Our Case Number: ABP-316828-23

Re: Tallaght/Clondalkin to City Centre BusConnect Core Bus Corridor Scheme.
Tallaght/Clondalkin to Dublin City.

Submission on behalf of Cllr. Mick Duff to An Bord Pleanala.

- **Reference the proposed introduction of a two lane Bus link bus route and cycle lanes, off the Greenhills Road and through the residential developments in the cul de sac at Birchview Avenue, in front of the existing two storey houses and behind the single storey houses at Parkview, ref General Arrangements sheets numbers 10 of 56 and 11 of 56**

Programme Title BUSCONNECTS DUBLIN CORE BUS CORRIDORS INFRASTRUCTURE WORKS			
Drawing Title TALLAGHT/CLONDALKIN TO CITY CENTRE CORE BUS CORRIDOR SCHEME STREET LIGHTING			
Drawing File Name BCIDA-ACM-LHT_RL-0809_XX_00-DR-EO-0010	Sheet Number 10 of 56	Status A	Rev M01

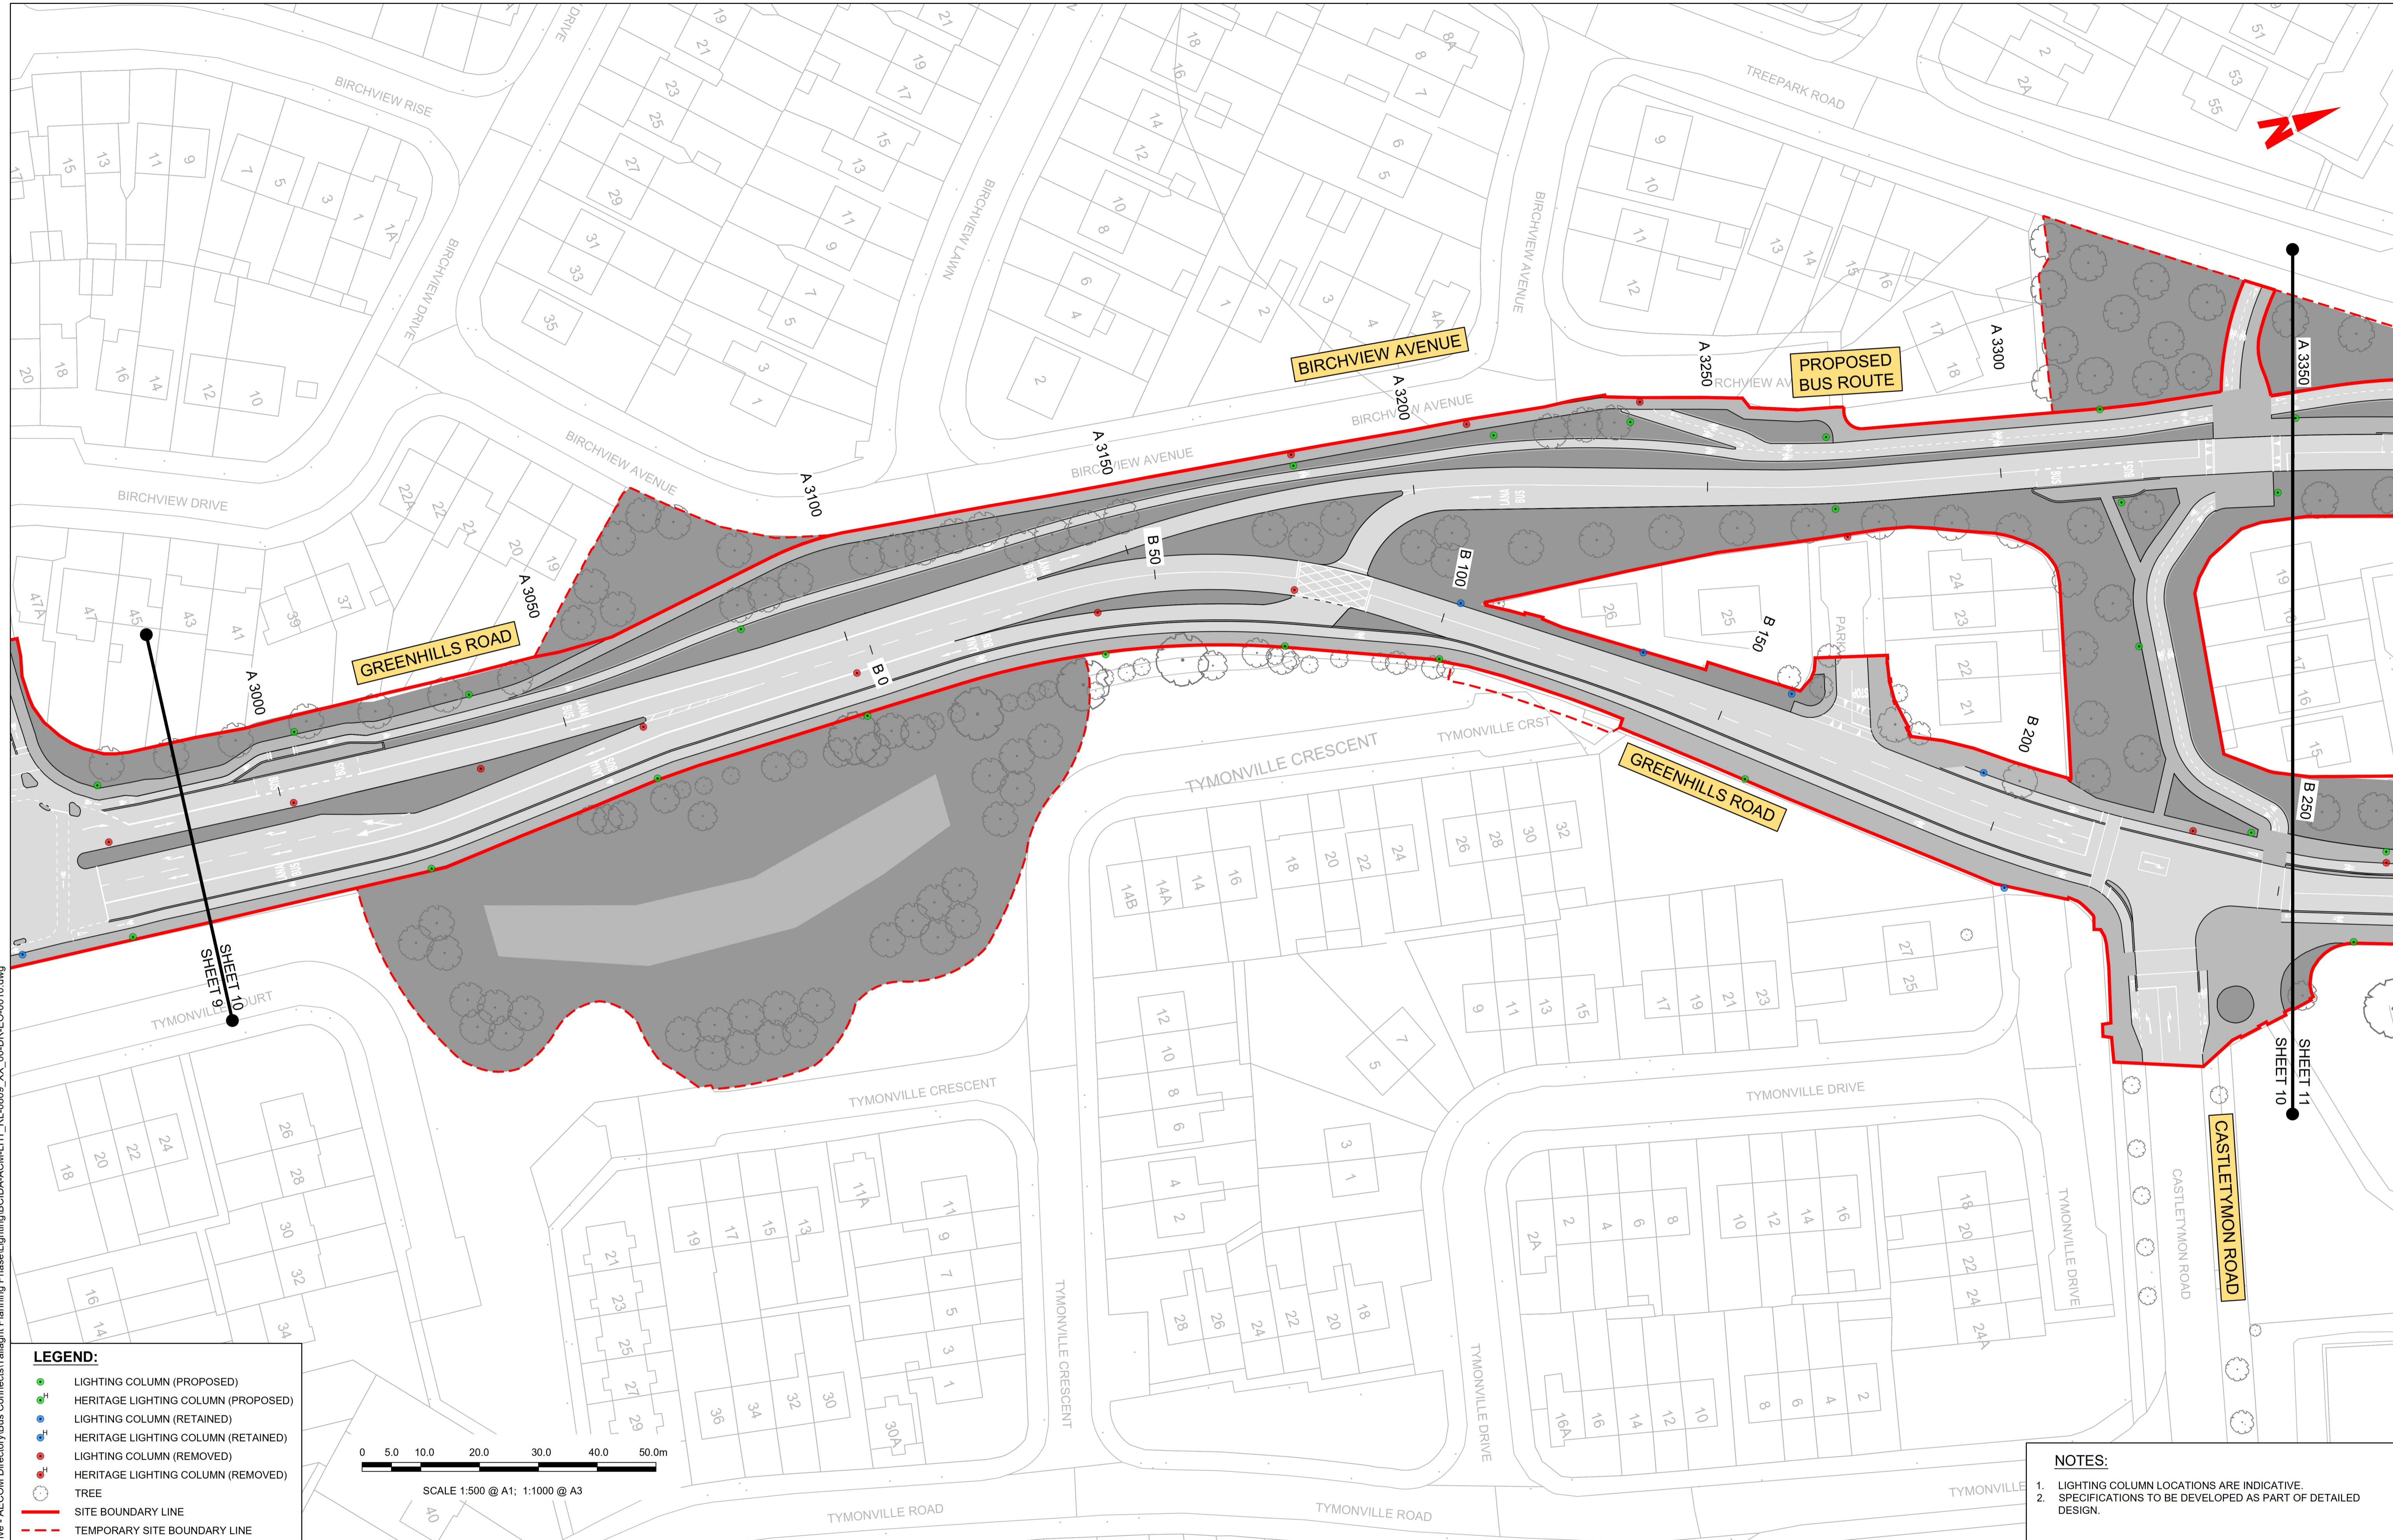
Submission on behalf of Cllr Mick Duff 26 St Aongus Crescent, Tymon North D24C7P9 re the Proposed Tallaght/Clondalkin BusConnects proposal to introduce a two lane Bus Lane and Cycle Tracks through the Green Open Space at Birchwood Ave and Parkview, Kilnamanagh, Dublin 24 as per the maps on General Arrangements sheets numbers 10 of 56 and 11 of 56.

- The Birchview area of Kilnarnagh celebrates their 40th anniversary this year and in that time, since residents first purchased their homes, they enjoyed a Green Open Space, directly in front of their homes, in a quite cul de sac. The Green Open Space currently has children's play equipment, such as a play house, goal posts and there is very strong evidence that the area is much used by children, adults and residents of other parts of Kilnarnagh who use this area as a Green Walkway, from Mayberry Road through to the Kilnarnagh Family Recreation Centre and to access Tymon Park at the footpath that traverses the lower part of this Open Space between Tree Park Road and the Greenhills Road. It is also used by students from Kilnarnagh to access Collaiste De Hide on Castletymon Road. If this proposed new bus lane goes through this area it will mean that those currently crossing via the pathway and crossing the Greenhills Road will now face having to journey across three roads and seven lanes to make their journey to school or to Tymon Park or Castletymon Library.

- The homes situated on Birchview Avenue are set back and separated from the heavy traffic of the Greenhills Road by their green open space. This proposal will bring Double Decker vehicles (buses) and bikes to the immediate front and sides of their homes, introducing an element of danger to their young children and grandchildren it will increase noise levels and potentially increase the risk of pollution by the introduction of buses into this quiet residential area. The removal of the Green Open Space will have a negative impact on the Community health and wellbeing, by removing a passive recreation area, removing a safe space for children and an exercise and safe walking area for senior citizens. The single storey houses in Parkview are set out in small cul de sacs, populated mainly by very young families and senior citizens. They are in the main accustomed to traffic passing their homes to the front and sides of their houses, along the Greenhills Road. This proposal will bring heavy traffic to the rear of their homes, particularly past their bedroom windows and introducing a new level of noise at the rear of their homes, while still being effected by passing traffic on the Greenhills Road. A double whammy of noise pollution!

- The plan proposes to remove three existing bus stops on the Greenhills Road and relocate them on the new bus lane. This again will impact on students from Collaiste De Hide and Scoil Iosa who can safely access the current 27 bus stops at Tymonville

(2340) and beside the Cuckoo's Nest (2339) and if the plans are approved, will now have to cross three roads to access the new proposed bus stops. This will also have an impact on people with mobility difficulties, who currently use the existing bus stops but will have to walk a much longer distance to get to the relocated stops, which in my humble opinion, defeats the purpose of accessibility and sustainability for those citizens.
